SSD_7417: REGIMENT MIXED-USE REDEVELOPMENT, UNIVERSITY OF SYDNEY, DARLINGTON CAMPUS

UNIVERSITY OF SYDNEY RESPONSE TO SUBMISSIONS

18 MAY 2017

Section at Brickwork

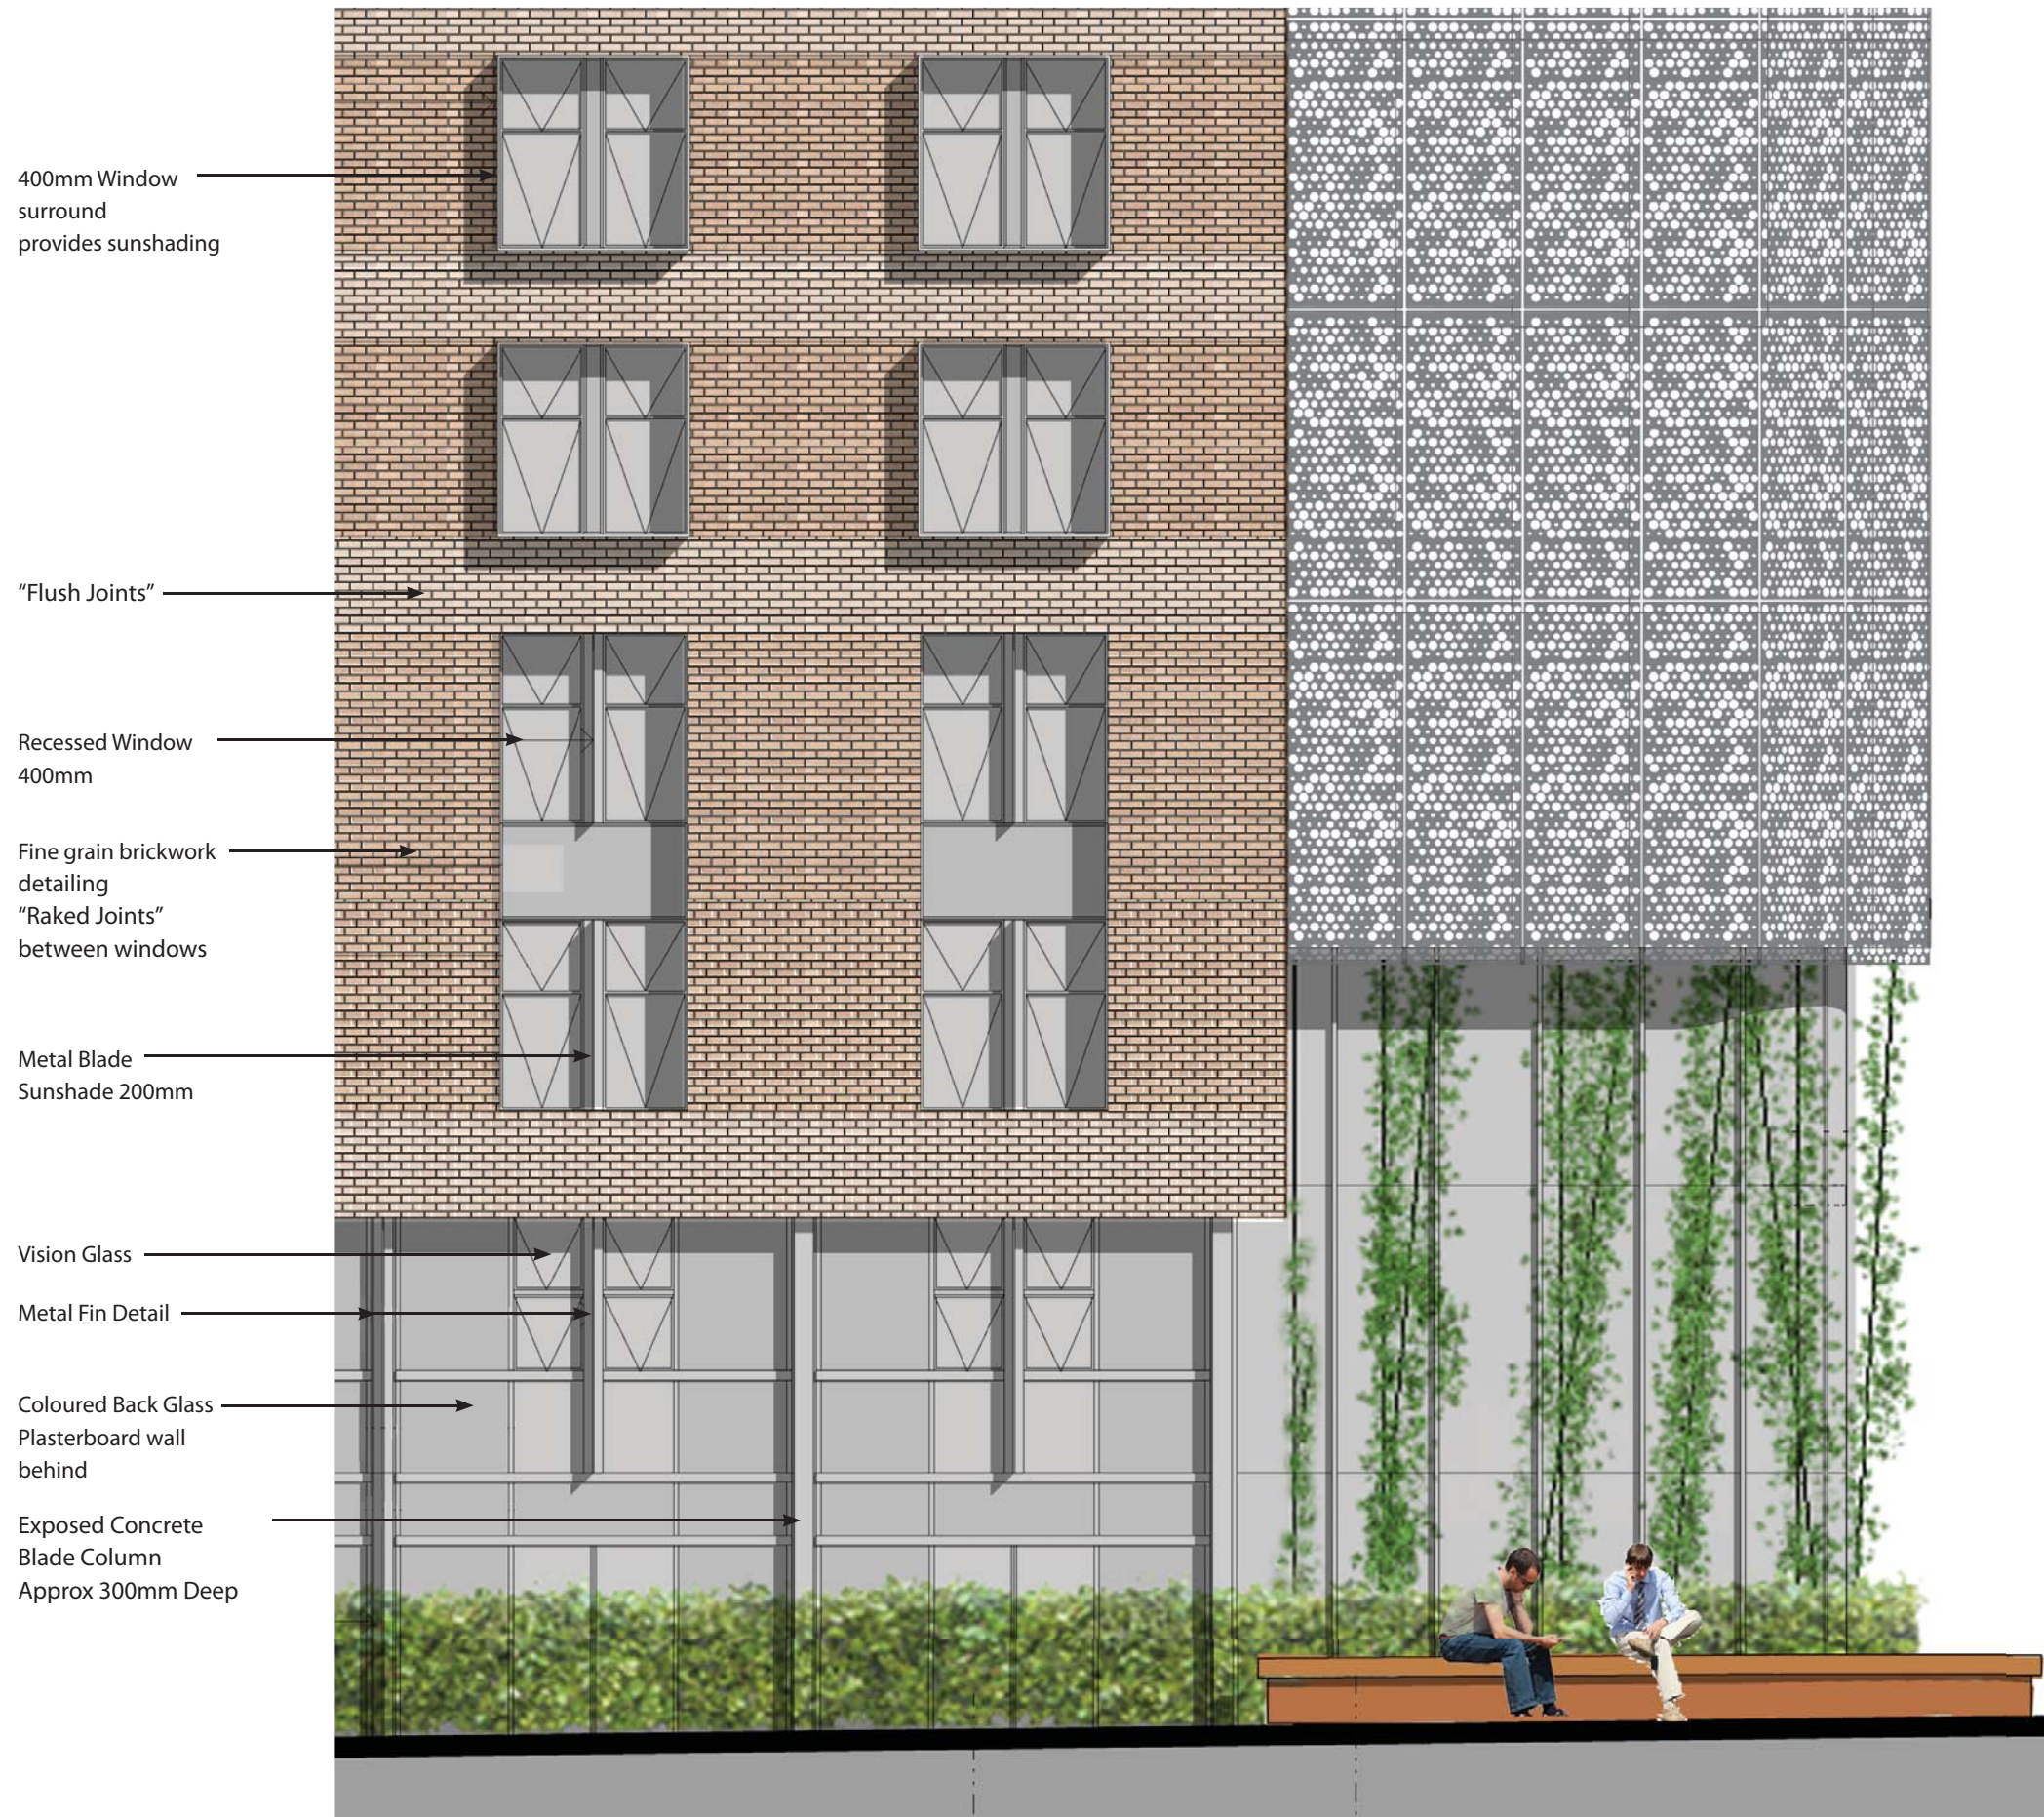
2. Integrated mixed use approach with the inclusion of campus-wide facilities within the building is supported	Noted
3. The sharp corner of the site at the intersection of Darlington Road and City Road represents a significant architectural opportunity and key visual place marker for the University. The current proposed form and building facade composition do little to celebrate this key contextual opportunity and are not supported.	Noted Please refer to the University's response under DPE Issue No.1 on page 3 of this document for a response to these queries.

4. Whilst the selection of masonry as the primary facade material is supported, the potential of brick both formally and decoratively is not fully exploited in the current design of the facades. Given the civic prominence of the building a considered and integrated approach to the form, mass and articulation of the brick is recommended.	Noted Please refer to the University's response under DPE Issue No.1 on page 3 of this document for a response to these queries.

SSD 7417 – REGIMENT MIXED-USE REDEVELOPMENT	
DPE ISSUE	USYD PROJECT RESPONSE
	<p>OPTION 2B</p> <p>With the introduction of a light weight decorative screen wrapping around a curved glazed flat iron corner, opportunity's open up for improvement as follows:</p> <ul style="list-style-type: none"> - The screen acts as a contemporary gateway to the University precinct, reflecting and responding to the University Indigenous Wingara Mura design principles. - As the screen turns the corner it sleeves the two brick facades on City and Darlington Road, managing the transition in scale. - The screen acts as solar protection from the western sun. - The screen filters light from the social spaces within the building, presenting as a delicate beacon and a unique place marker and identifier. - At the ground and first floor, the screen stops to reveal an active and transparent 'shop front' to the student spaces. The building has been pulled back to respect and remember the garden which has been removed. The green edge continues from the pocket park opposite. Bench seating may create a meeting and resting point in the shade, along the expansive City Road. - The green vertical elements, soften and enhance the hard urban edge, and humanise the corner. - The first floor slab has been removed at the corner to create a two story space, with a highly active student space within. - The veiled screen continues along the high level frontage to Darlington Street, improving privacy to the upper level spaces. The brick screen to the lower levels is also extended to reduce the glazed area, and create more unity between the two street facades.
